Re: Home Planning Office Drainage Report

July 9, 1979

A review of the drainage report has resulted in the following observations:

DRAINAGE REPORT  
FOR  
OFFICE BUILDING

HOME PLANNING OFFICE BLDG.	
Project No.	EXISTING TOPOGRAPHY
Site	ALBUQUERQUE, NEW MEXICO
Job No. 79-077	Sheet 1 of 2
Drawn By J.J.F.	Date MAY 1979
Checked By RRB	Scale 1" = 20'

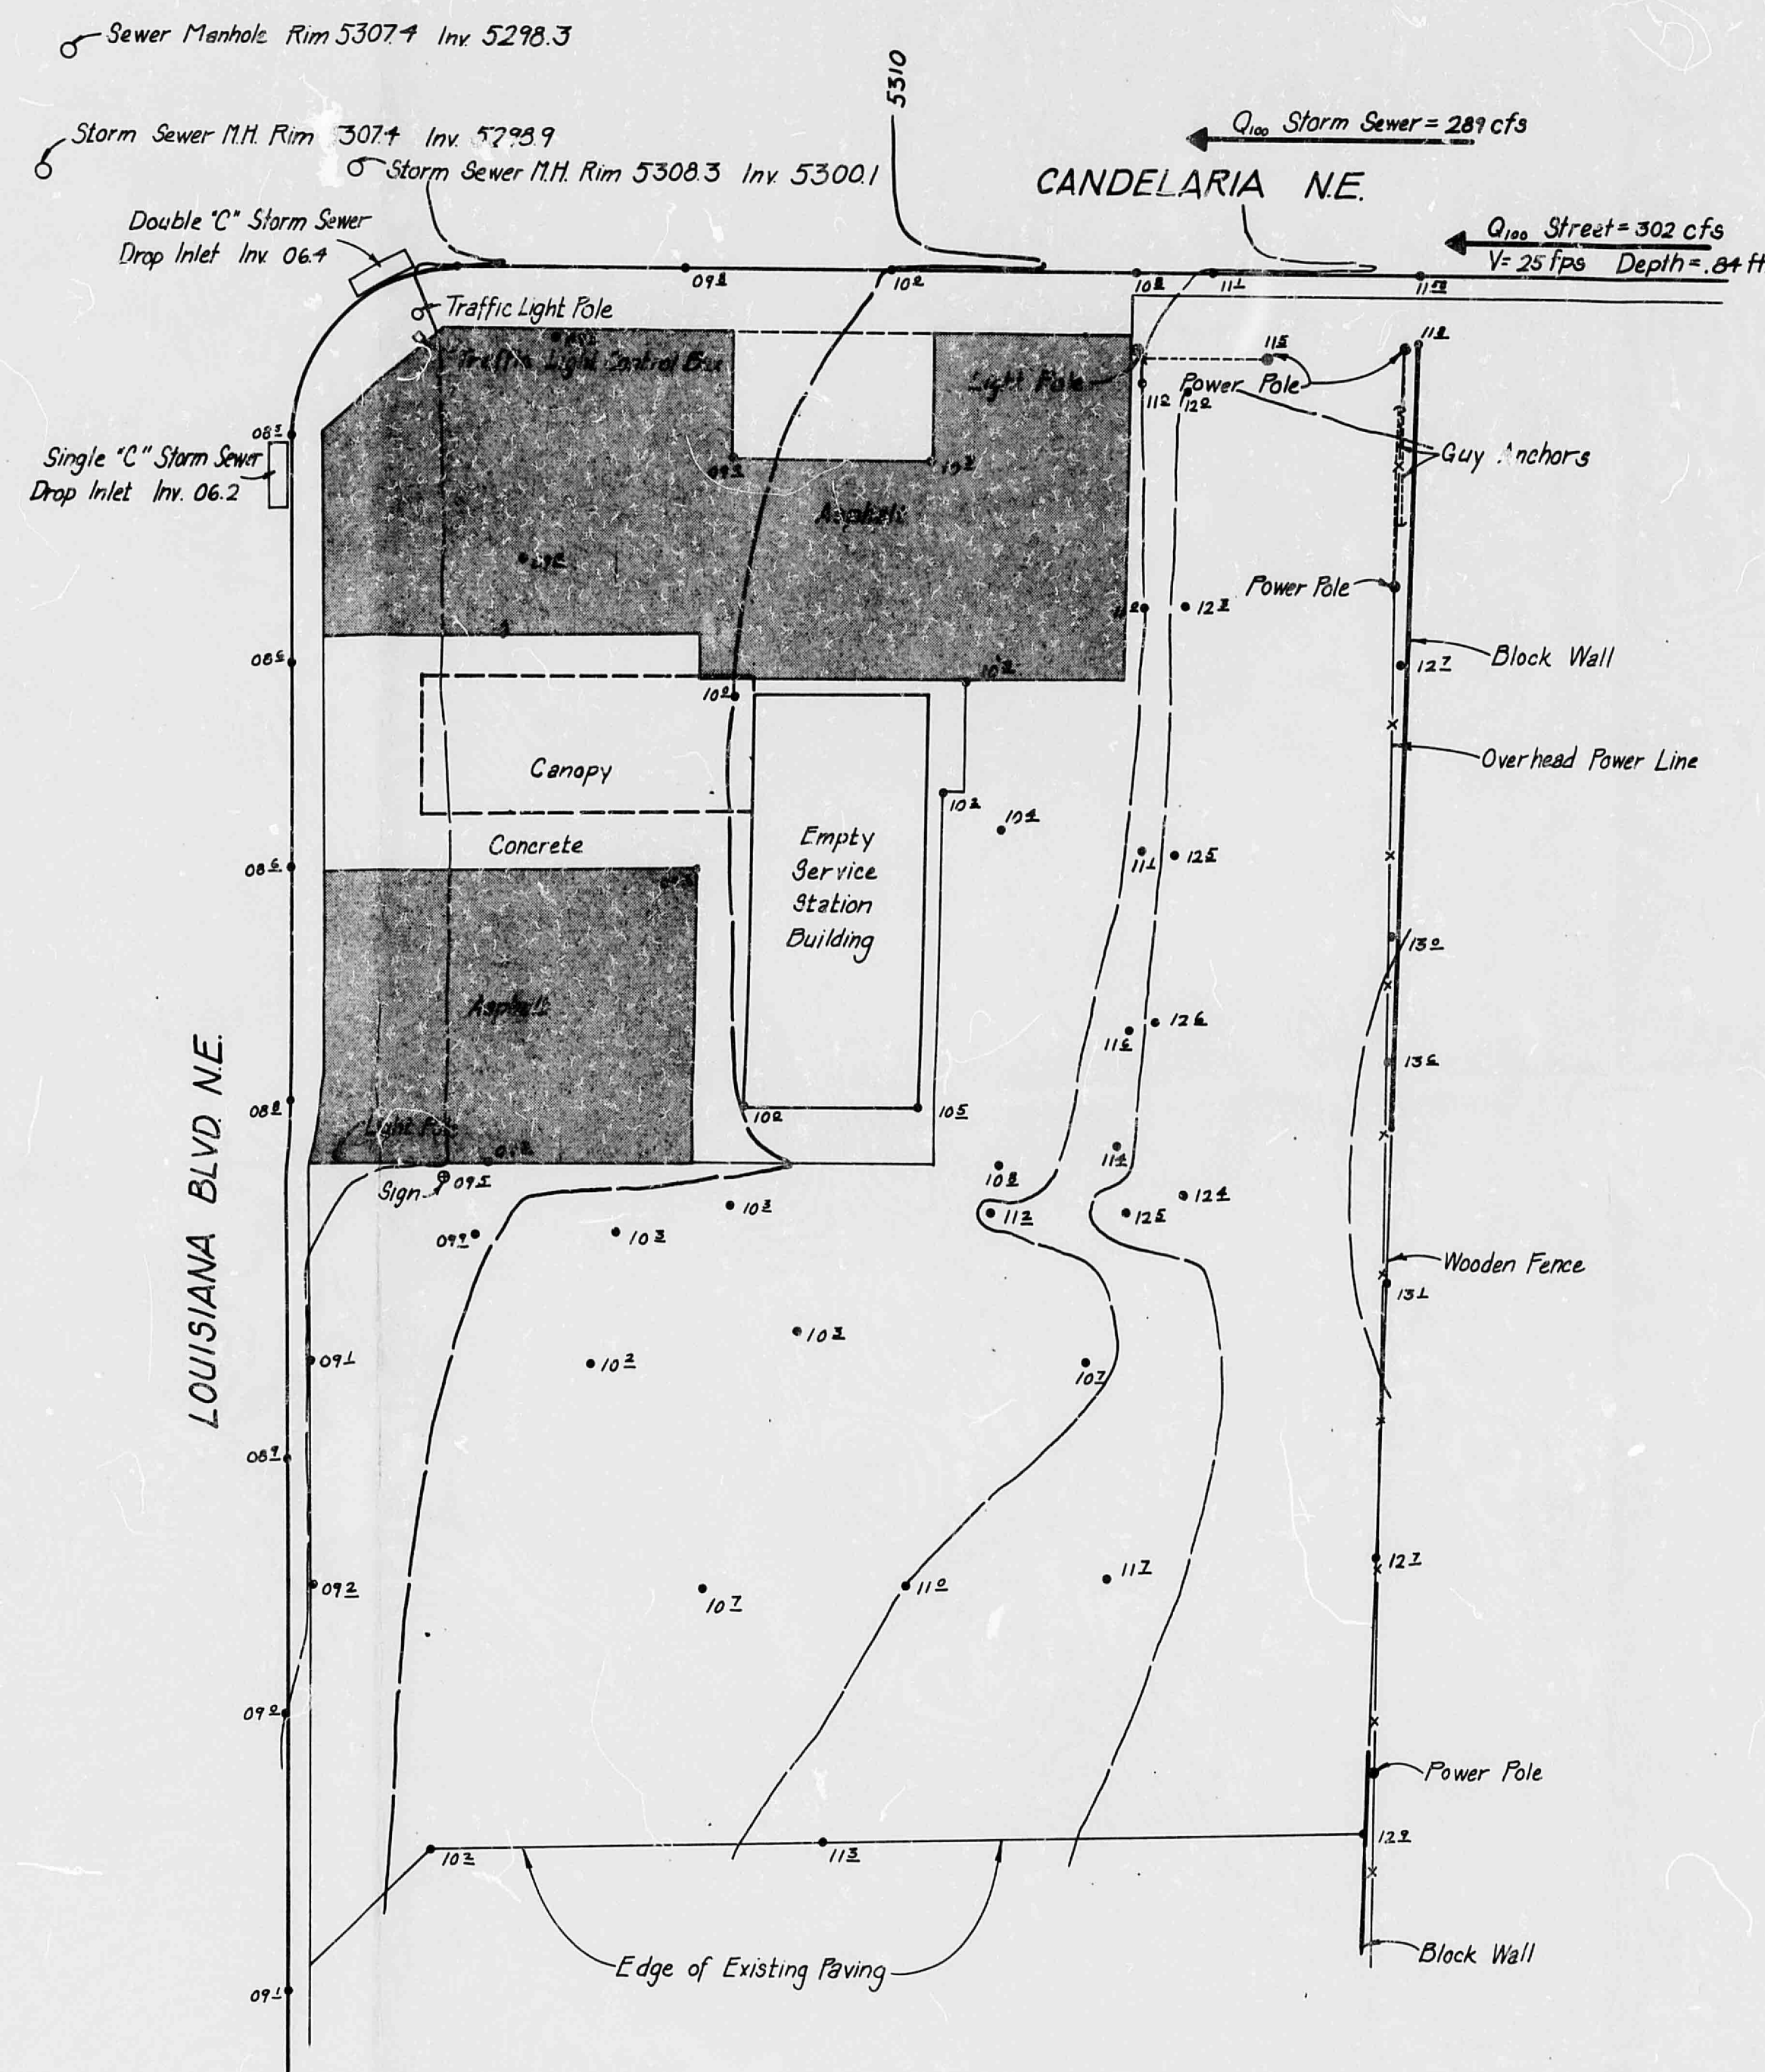
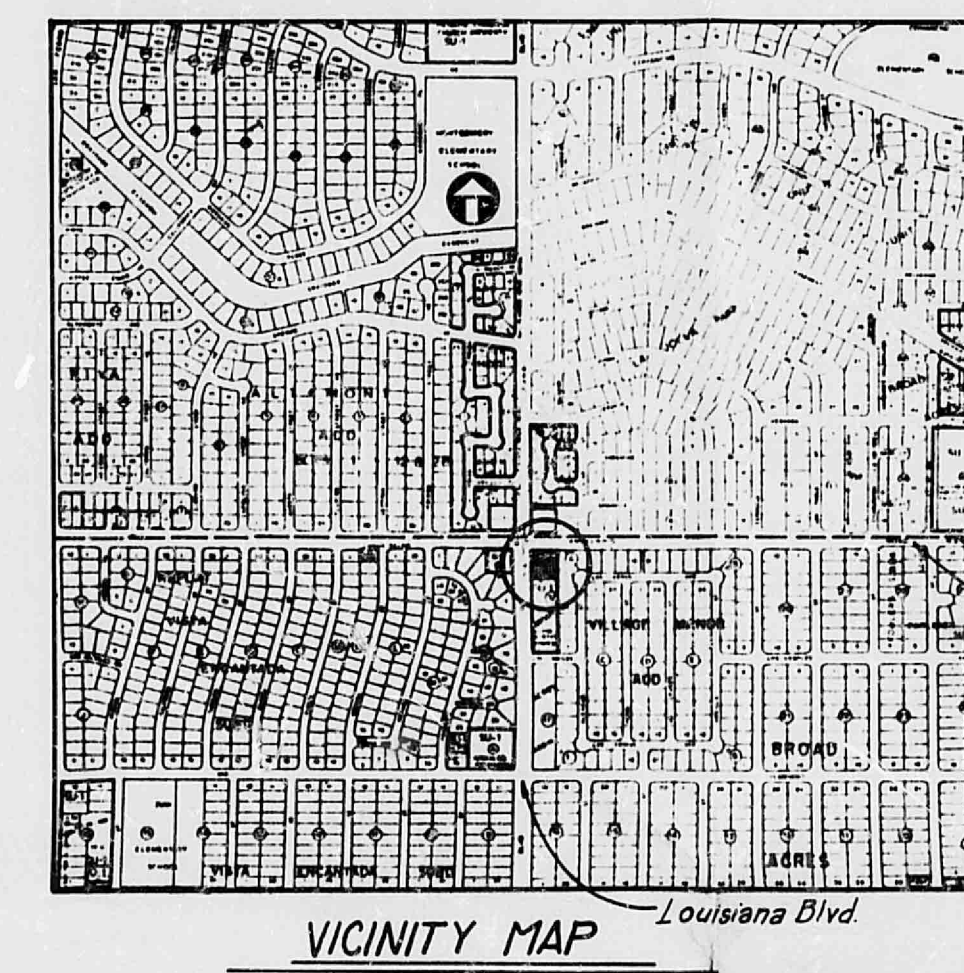
Since only 3664 sq. ft. of the 22,000 sq. ft. presently undisturbed ground will be landscaped (the remainder being paved or impervious) sufficient ponding volume must be supplied to compensate for the increased imperviousness. The ponding volume required is estimated in 2,000 cu. ft. rather than the 730 cu. ft. indicated in the report; this volume can be provided with a detention area in the parking lot, if the release rate will allow the emptying of the pond in no less than 24 hours. Alternatively, a french drain as shown in the attached sketch, can supply the ponding requirement. A combination of the two alternatives would also be acceptable.

Secondly, the depth and velocity data for the 100 year flow in Candelaria seem inconsistent with the estimated discharges. Please supply a verification of the computed 25.5 ft. per second velocity for the anticipated flow. Please submit also a map outlining the watershed that has been considered to be draining in Candelaria. With regard to the details that have been supplied with the report, I note that the ponding area is not clearly identified to allow the verification of the computations for ponding capacities. Additionally, geometric configuration of the ponding area will be needed for both sections and computations to demonstrate required pond volume.

The site grading plan indicates the proposed landscaped area on the west and north sides of the building drains directly to the adjoining streets. However, the calculations use this area in adjusting "C" value of the area contributing to the pond area. The use of this landscaped area in determining the complete "C" is inappropriate. Additionally, the drainage report must account for southwestern landscaping underlain with polyethylene film, or should state the intended type of landscaping.
